From: Laura Gibbons <Laura.Gibbons@arun.gov.uk>
Sent: 21 September 2021 08:16
To: Planning.Responses <Planning.Responses@arun.gov.uk>
Subject: RE: Planning Consultation on: A/168/21/PL

Engineers Comments Regarding Surface Water Drainage

Application No: A/168/21/PL

Description of Works: Erection of 76 No. dwellings, means of access, public open space, play areas, associated infrastructure & landscaping. This application is a Departure from the Development plan, is in CIL Zone 5 and is CIL Liable as new dwellings & affects a Public Right of Way.

Infiltration Test Results and Calculation of Infiltration Rates

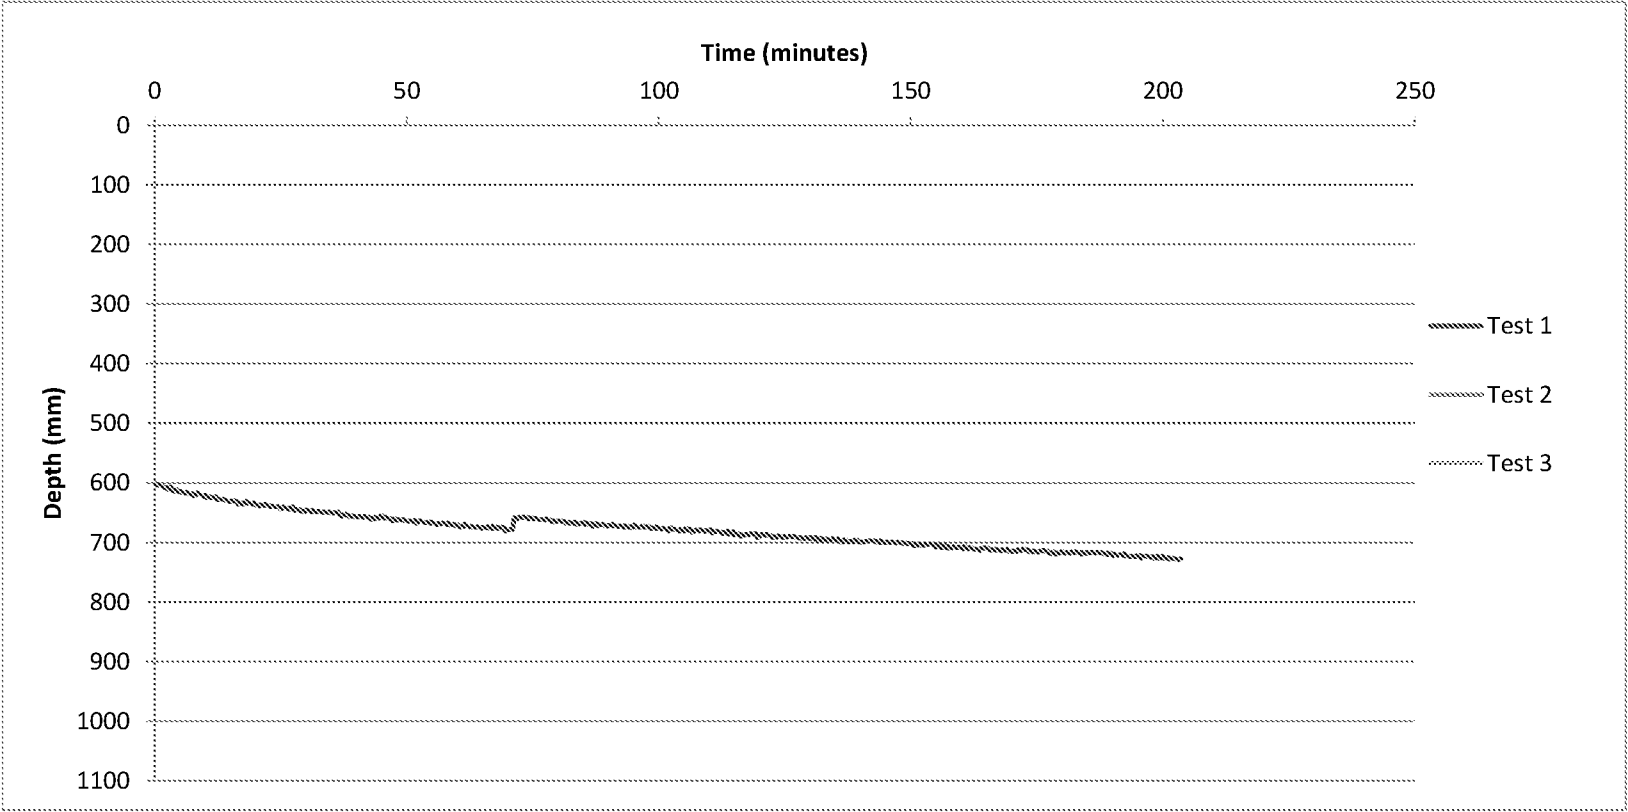
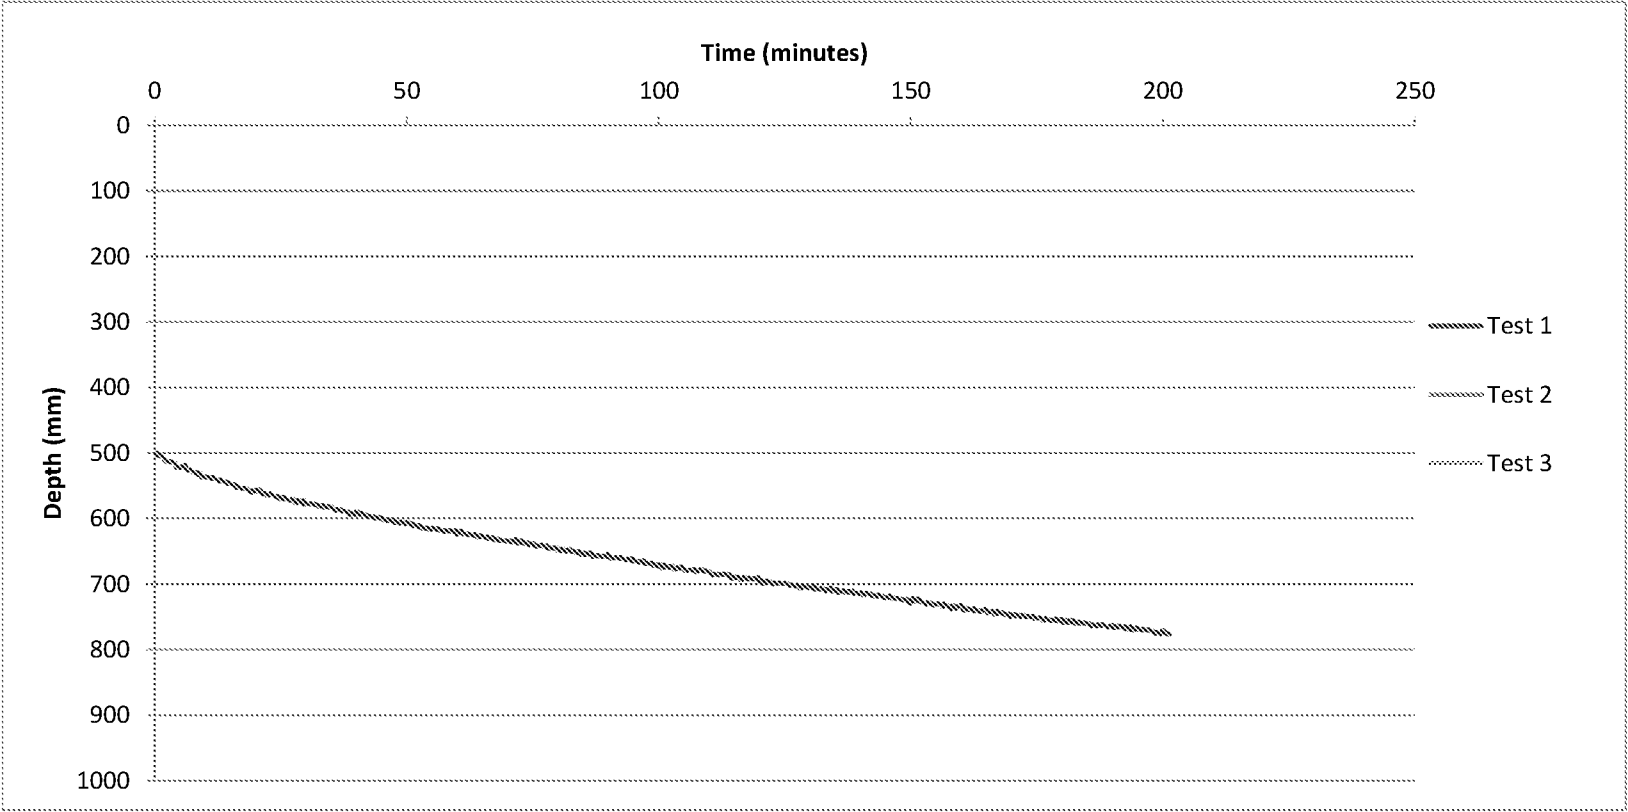
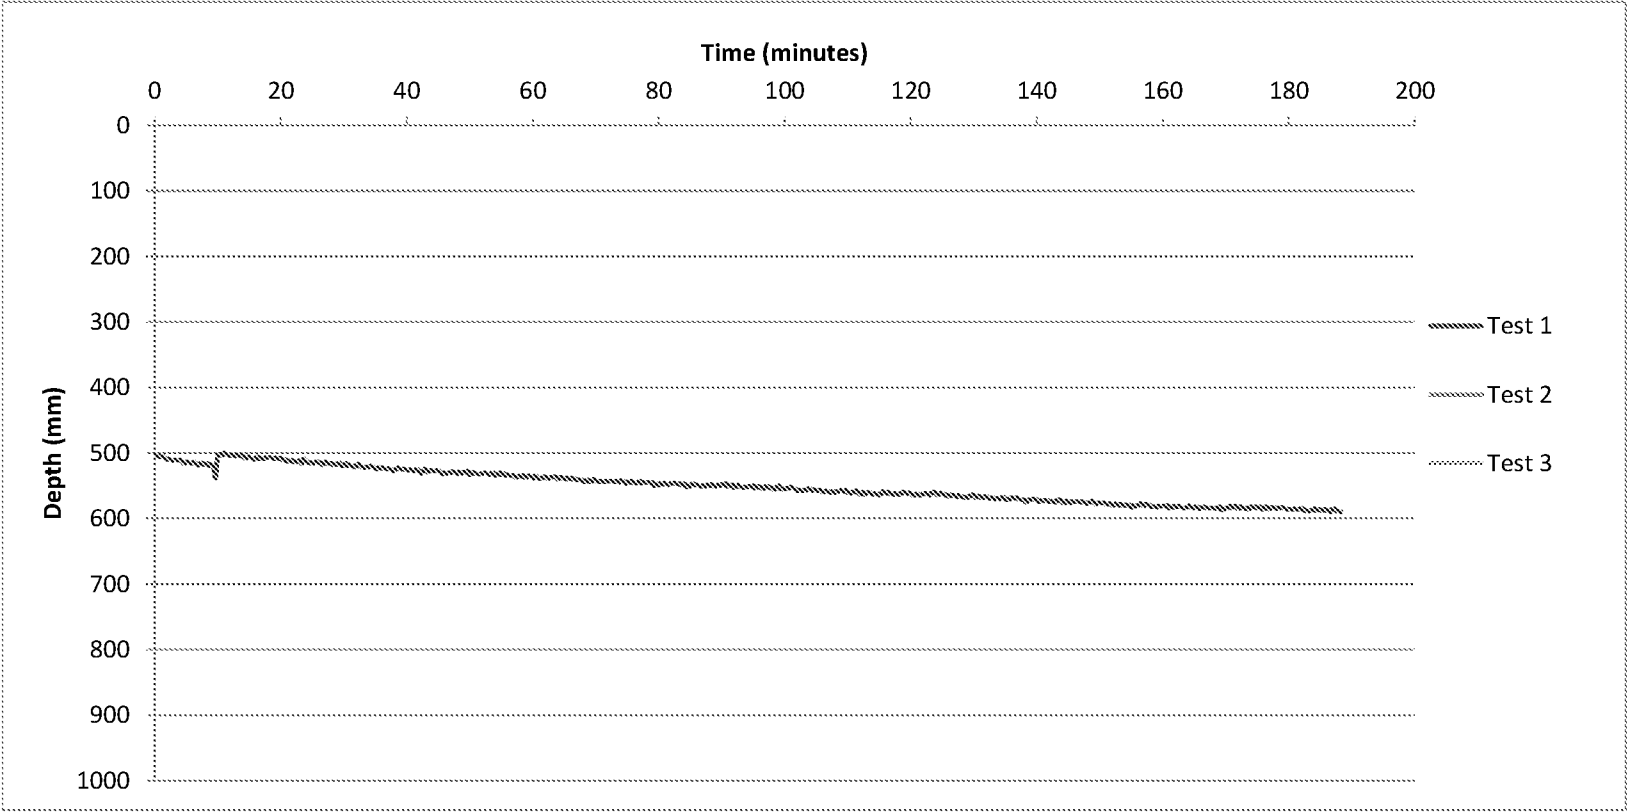
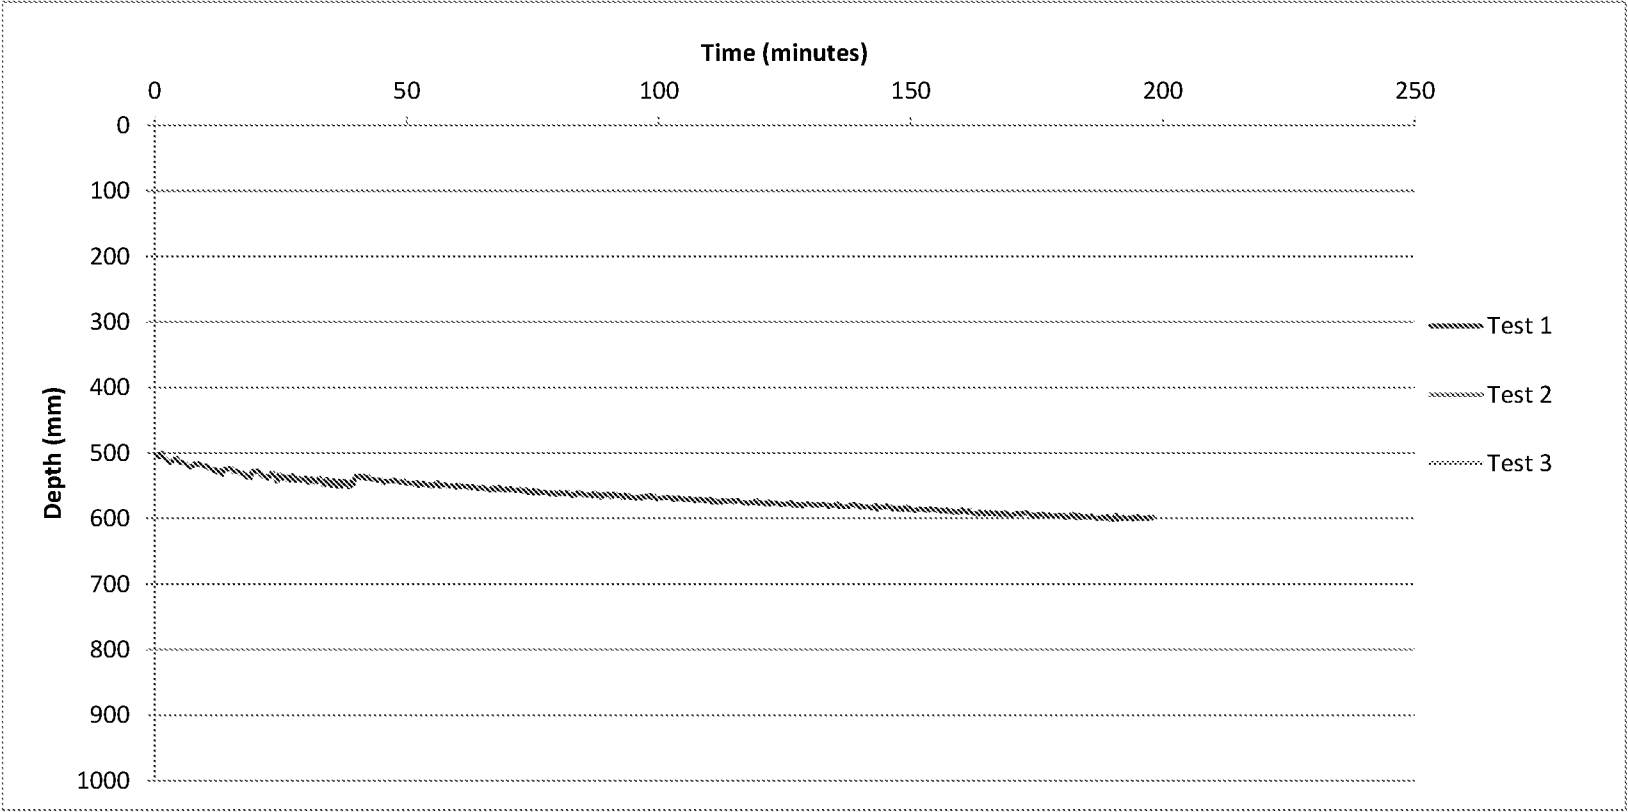
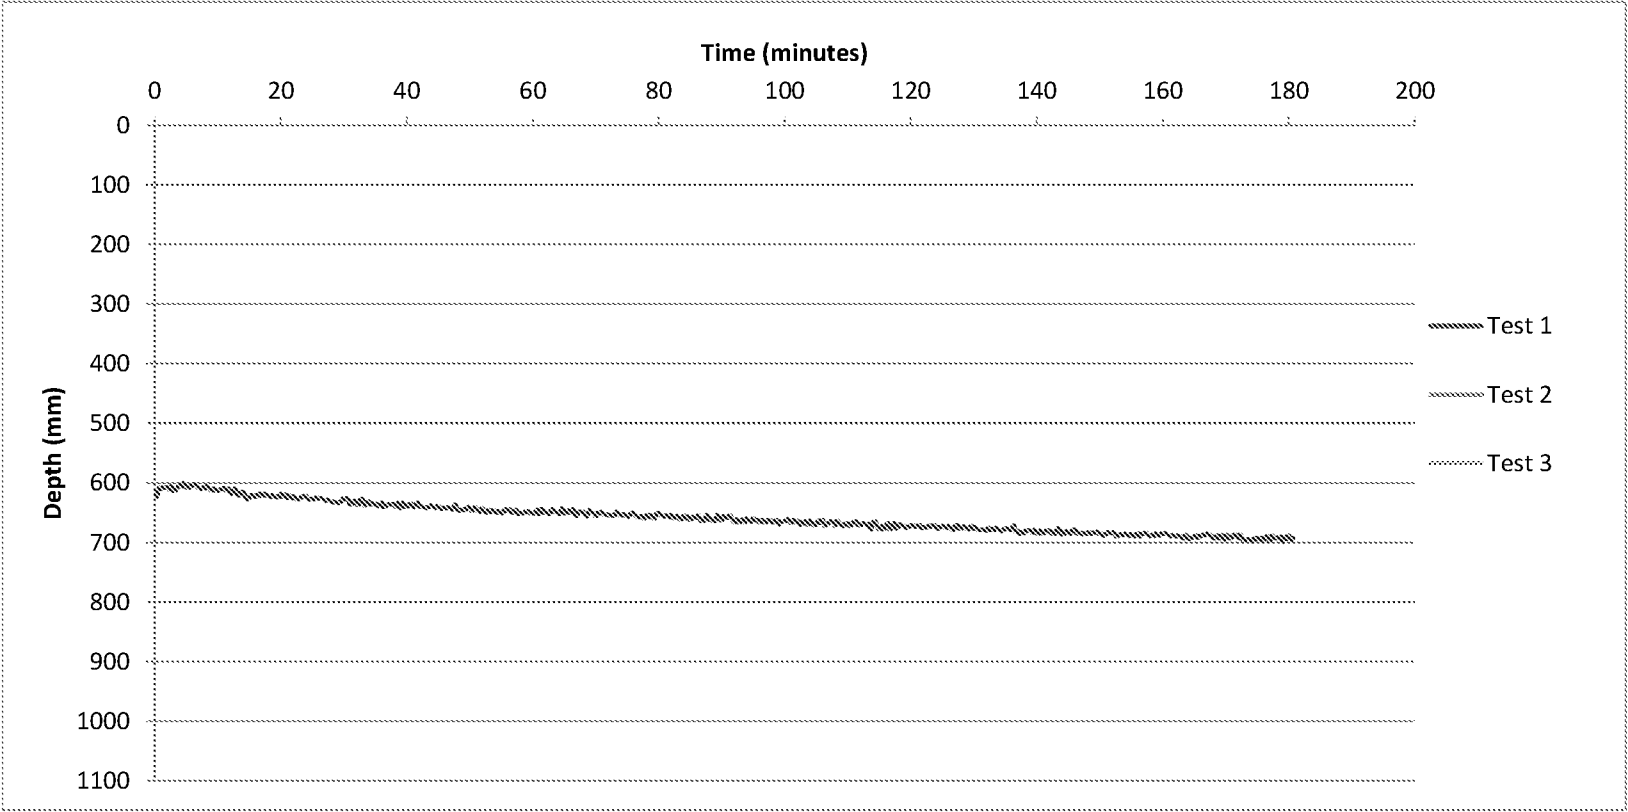
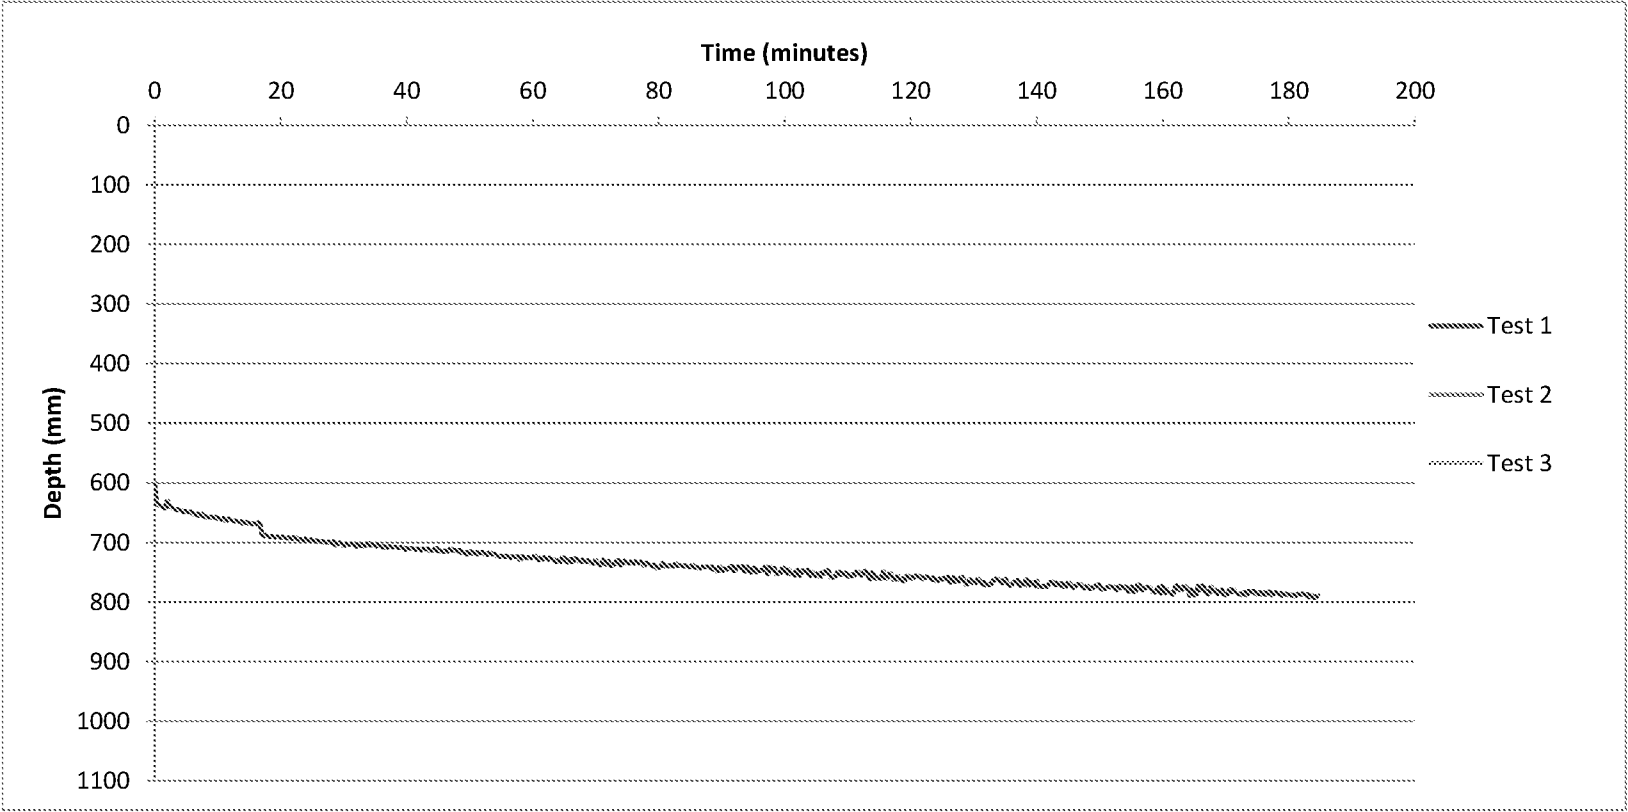
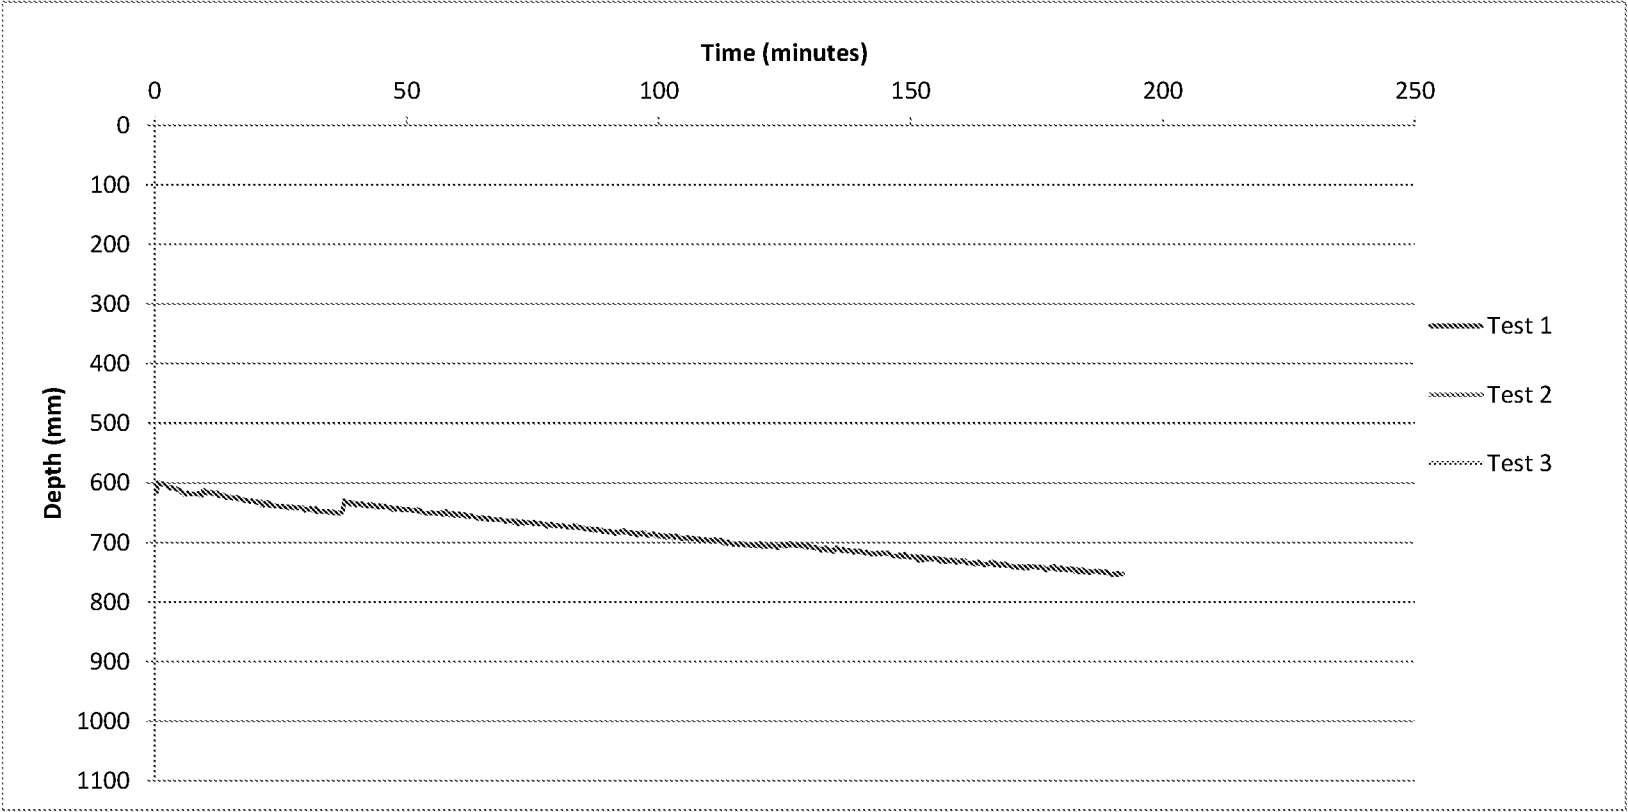
A surface water drainage strategy has been submitted with this application. The strategy identifies an attenuation drainage strategy with discharge limited to 2.9l/s. We note that winter groundwater monitoring has been completed and ground water was found at just over 1m depth throughout the site. Winter infiltration testing was completed, but three repeat tests were not completed at any location. The single test completed at each location indicate that infiltration is viable here. Full winter infiltration testing in accordance with BREDG365 must be completed.

“Infiltration rates for soakage structures are to be based on percolation tests undertaken in the winter period and at the location and depth of the proposed structures. The percolation tests must be carried out in accordance with BRE365, CIRIA R156 or a similar approved method and cater for the 1 in 10 year storm event plus 40% on stored volumes (allowance for climate change) between the invert of the entry pipe to the soakaway, and the base of the structure. It must also have provision to ensure that there is capacity in the system to contain below ground level the 1 in 100 year storm event plus 40% on stored volumes. Adequate freeboard must be provided between the base of the soakaway structure and the highest recorded annual groundwater level identified in that location. Any SuDS or soakaway design must include adequate groundwater monitoring data to determine the highest winter groundwater table in support of the design. The applicant is advised to discuss the extent of groundwater monitoring with the Council's Engineers.
